Consultation Response from KC, Highways Development Management
2026/90331 5, Park Riding, Northgate, Honley, Holmfirth, HD9 6QL
Change of use and alterations to convert residential annex to 1 dwelling
Date Responded: 03/07/2026 Responding Officer: CNB Responding Ref: K3-50/32
This application is for the change of use and alterations to convert a residential annexe to a two-bed detached dwelling within the grounds of an existing dwelling with a shared access on to C574 Northgate a 30mph tertiary distributor road of approximately 5.3m width with a footway on the side of the application site and limited street lighting present. There is a PROW footpath HOL/15/70 located to the northeast of the application site that terminates at the site access. This application was initially discussed at Highway Surgery where the HDM team had concerns with the proposals given the constrained layout of the site and access and presence of the PROW. The application was accompanied by a Highways Note dated 3rd Feb 2026 from Aimee Thompson Transport Planning. The proposals would remove the annexe designation from the proposal site and this would become an independent detached dwelling and this would inten

TITLE: SWEPT PATH ANALYSIS

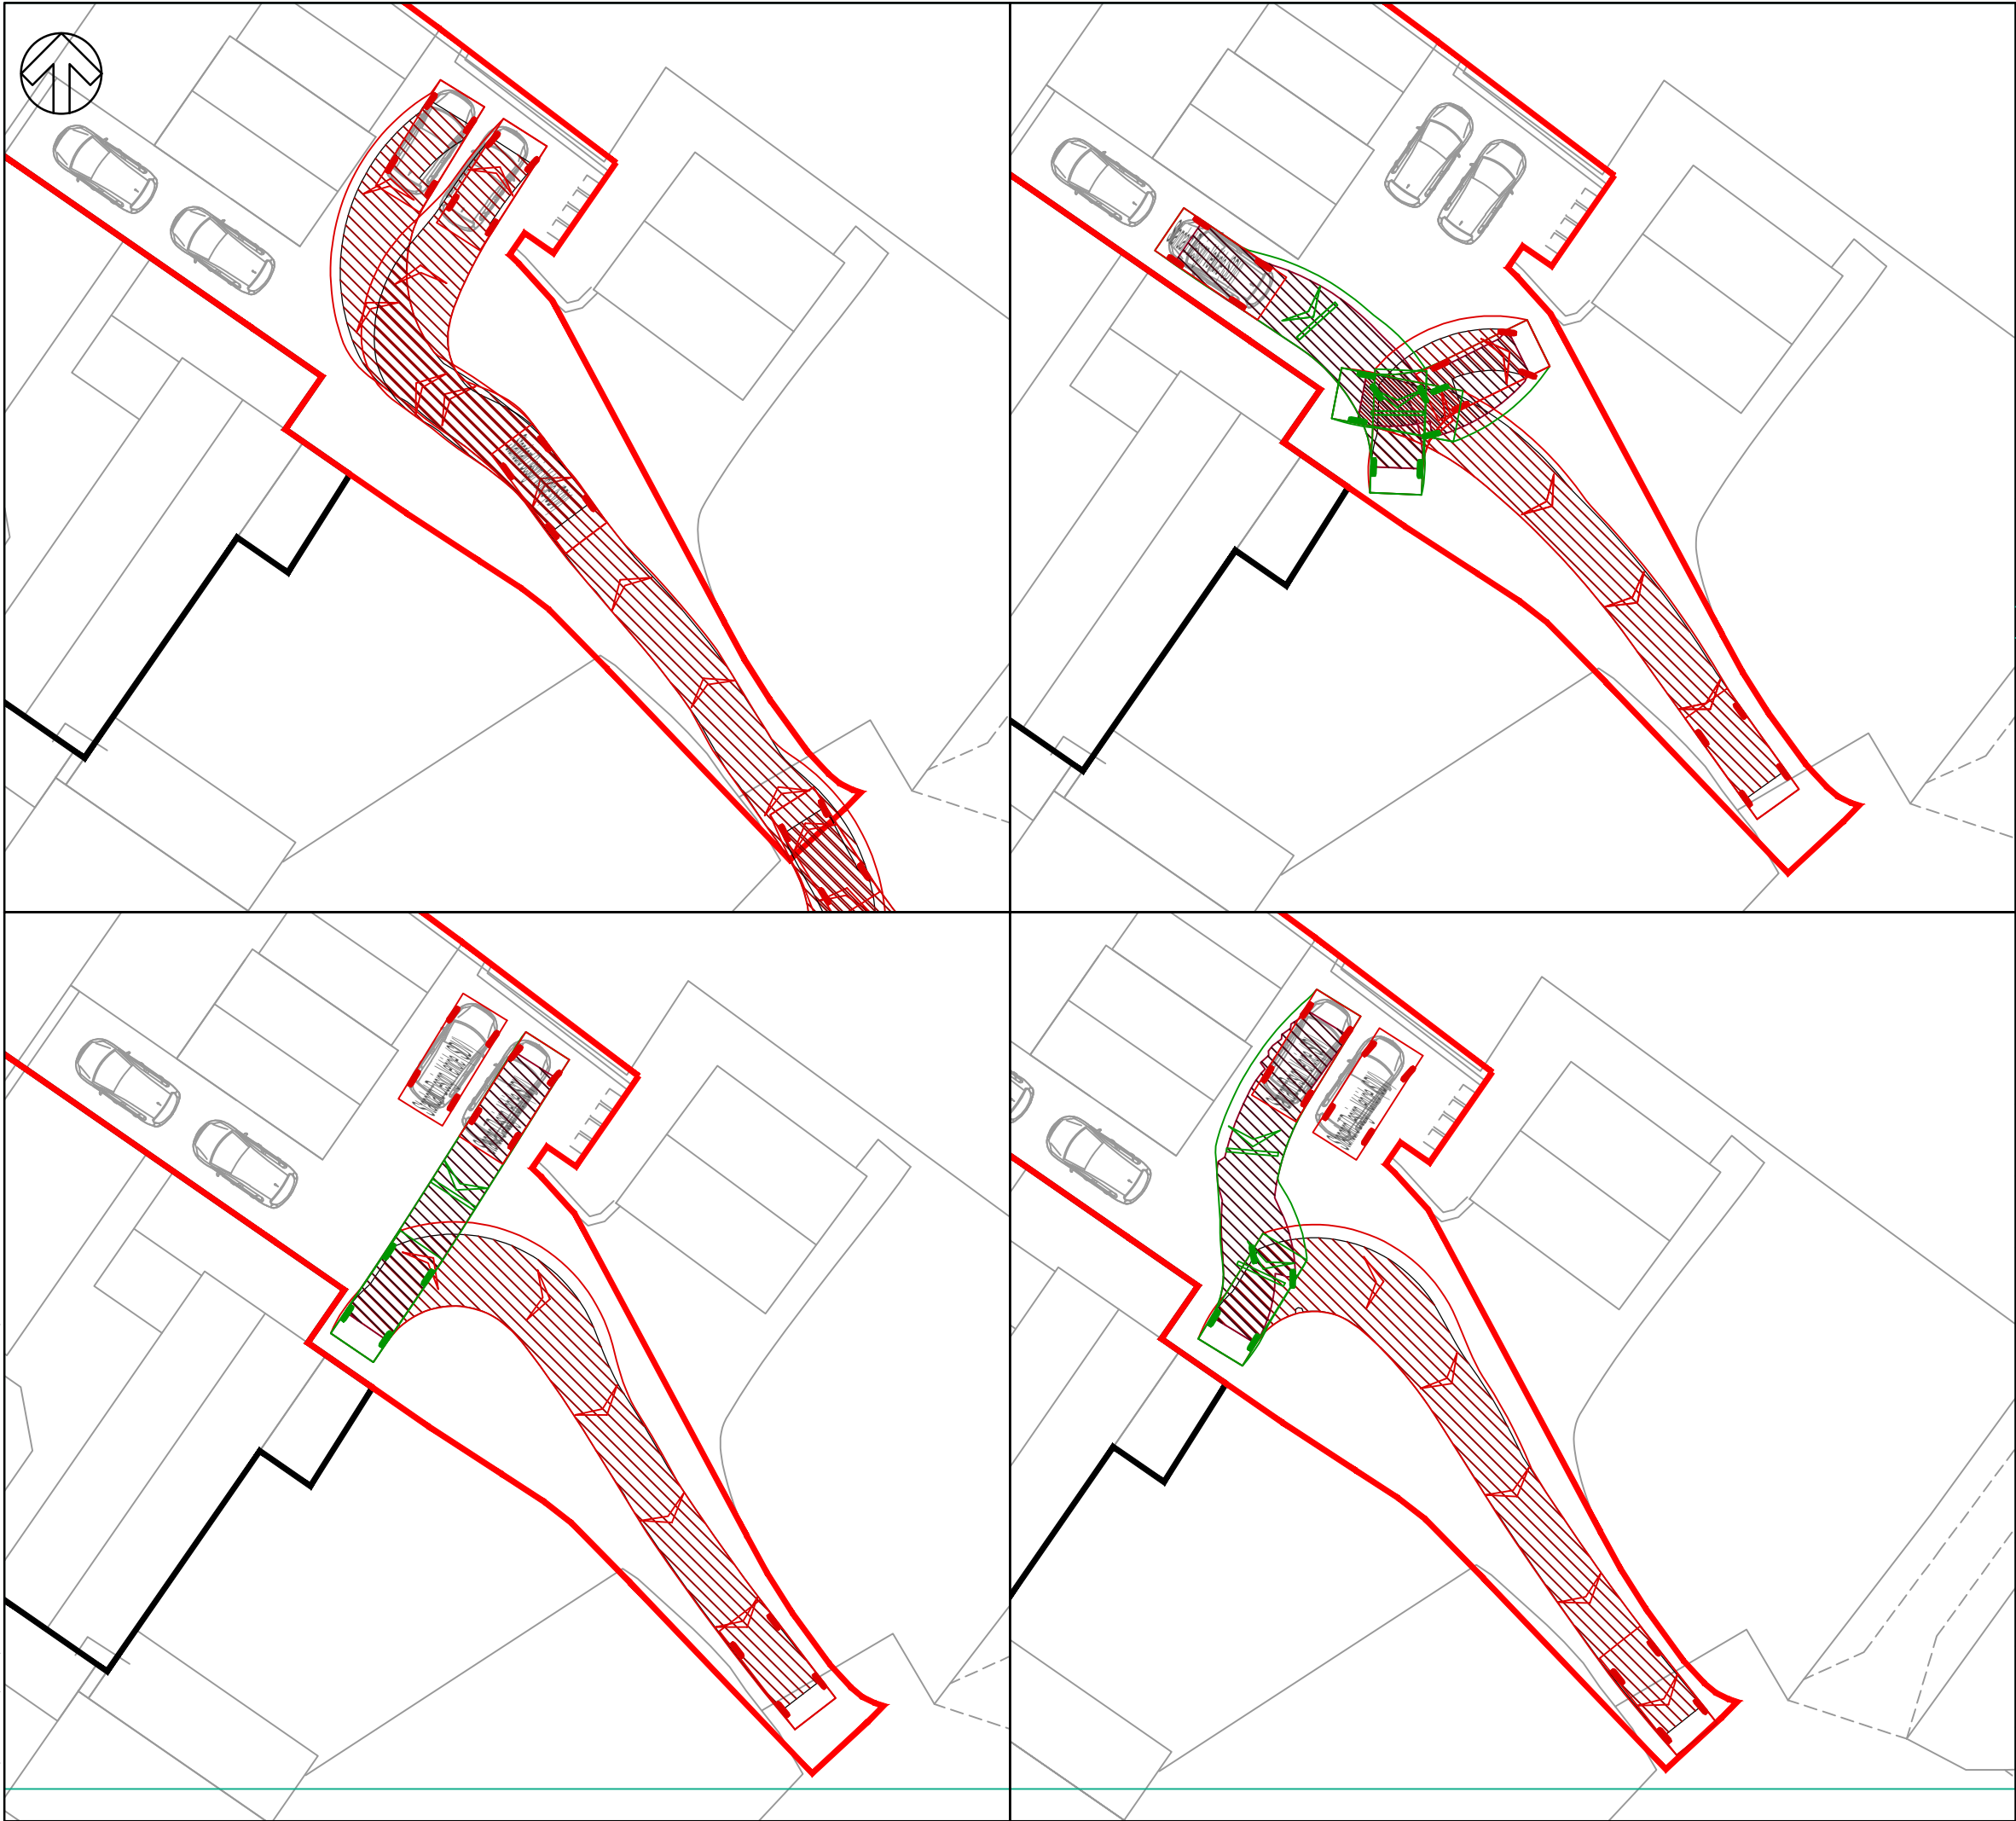
all the parking spaces, although there may be issues if the rear car in the tandem parking spaces needs to leave as there is very limited space to temporarily relocate the front car and still allow easy manoeuvring and access. No swept path analysis was provided for the garage and parking spaces for No 3 Park Riding, although there looks to be sufficient space to allow turning and so this is not a concern. We would like to see the drawings marked with an area of shared turning to protect this space from obstruction to guarantee that all cars can turn and manoeuvre on site so they can enter and exit the site in forward gear for the lifetime of the development.

Drawing Title
Proposed Site Layout Plan

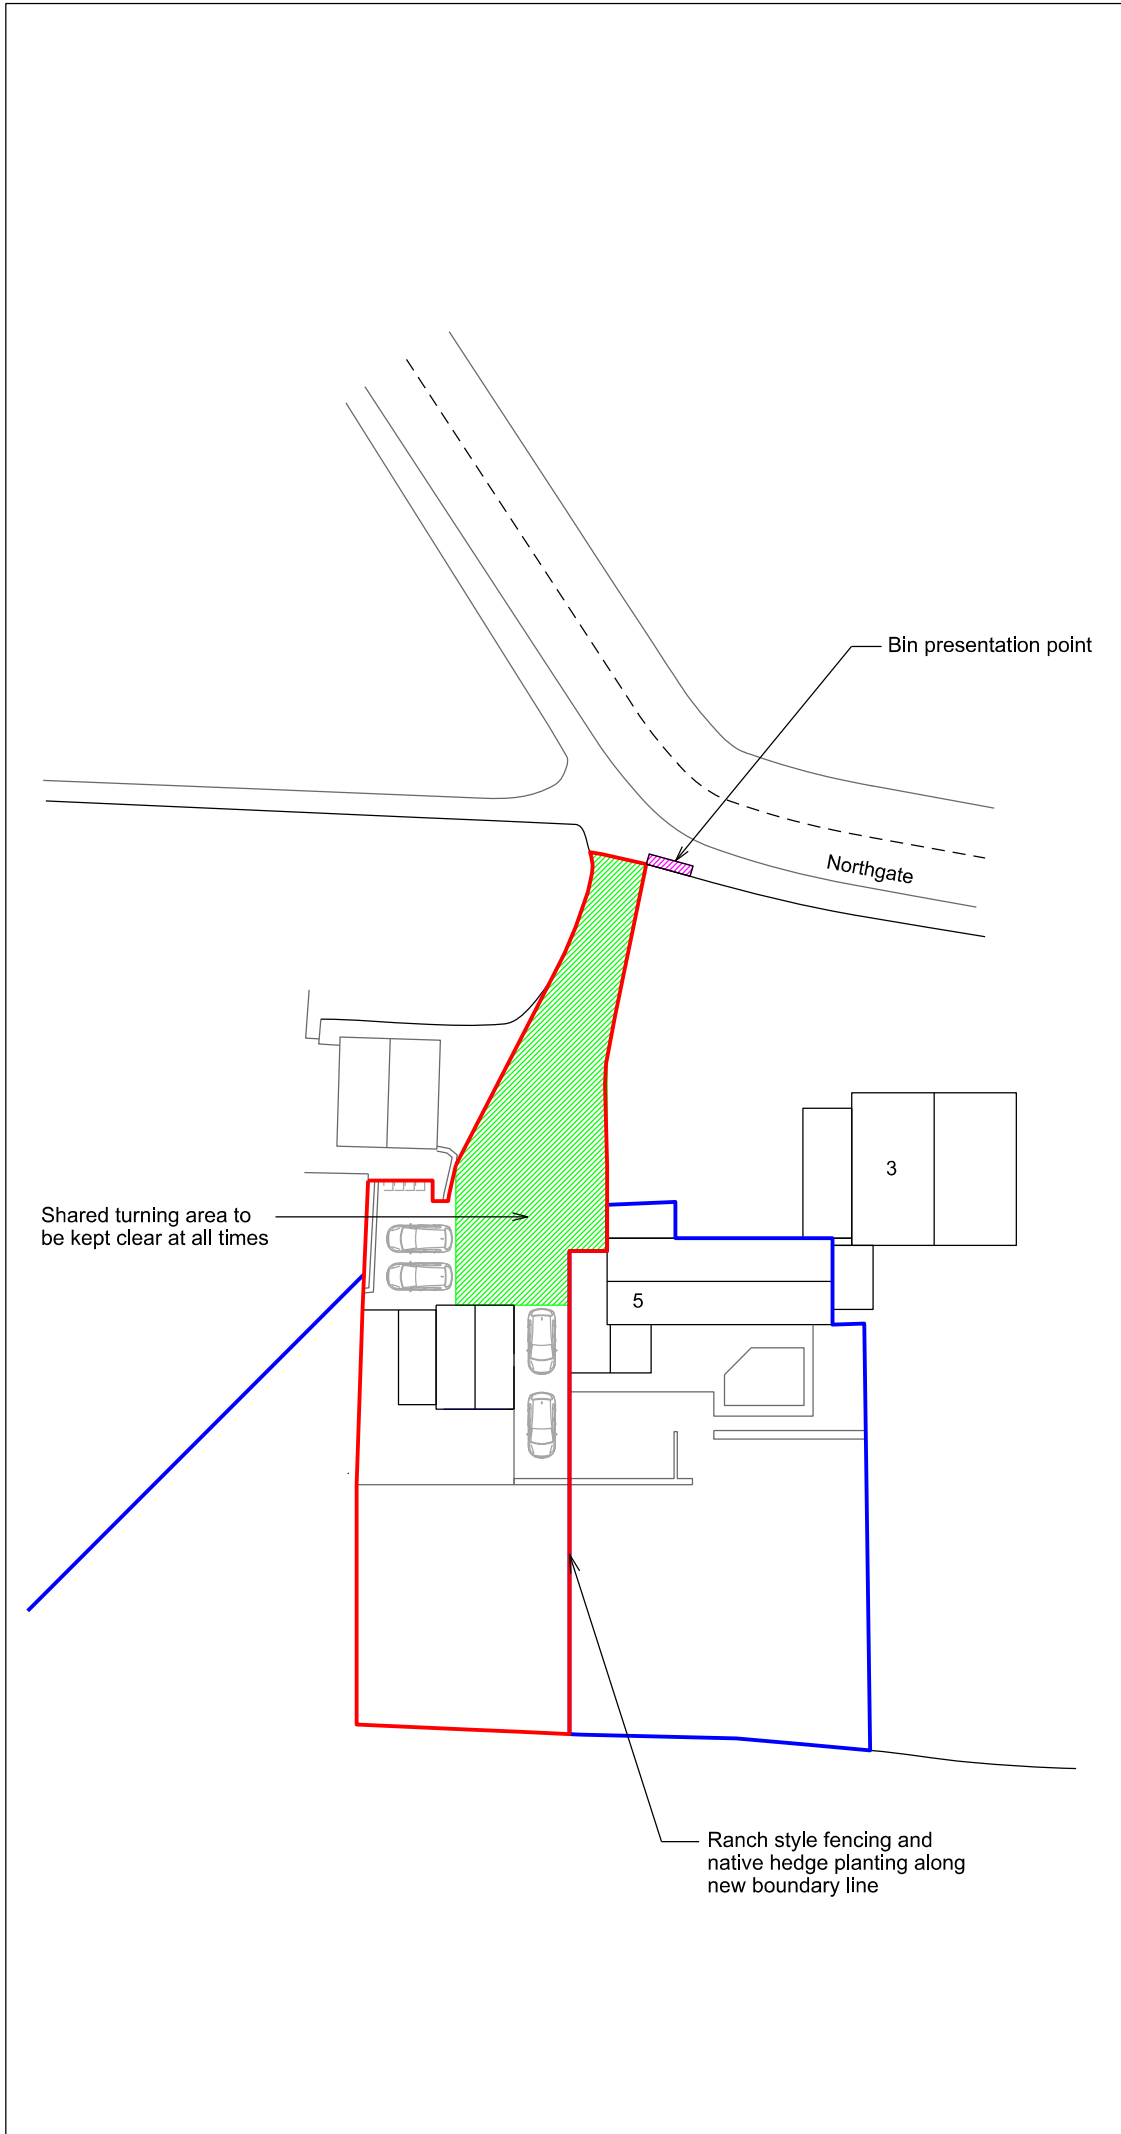
We would also need to see the location of a bin collection presentation point clearly indicated on a drawing and this should be located where it is accessible to collection crew, but where it won't obstruct either the parking spaces, access or turning area or the footway or highway for road safety reasons.
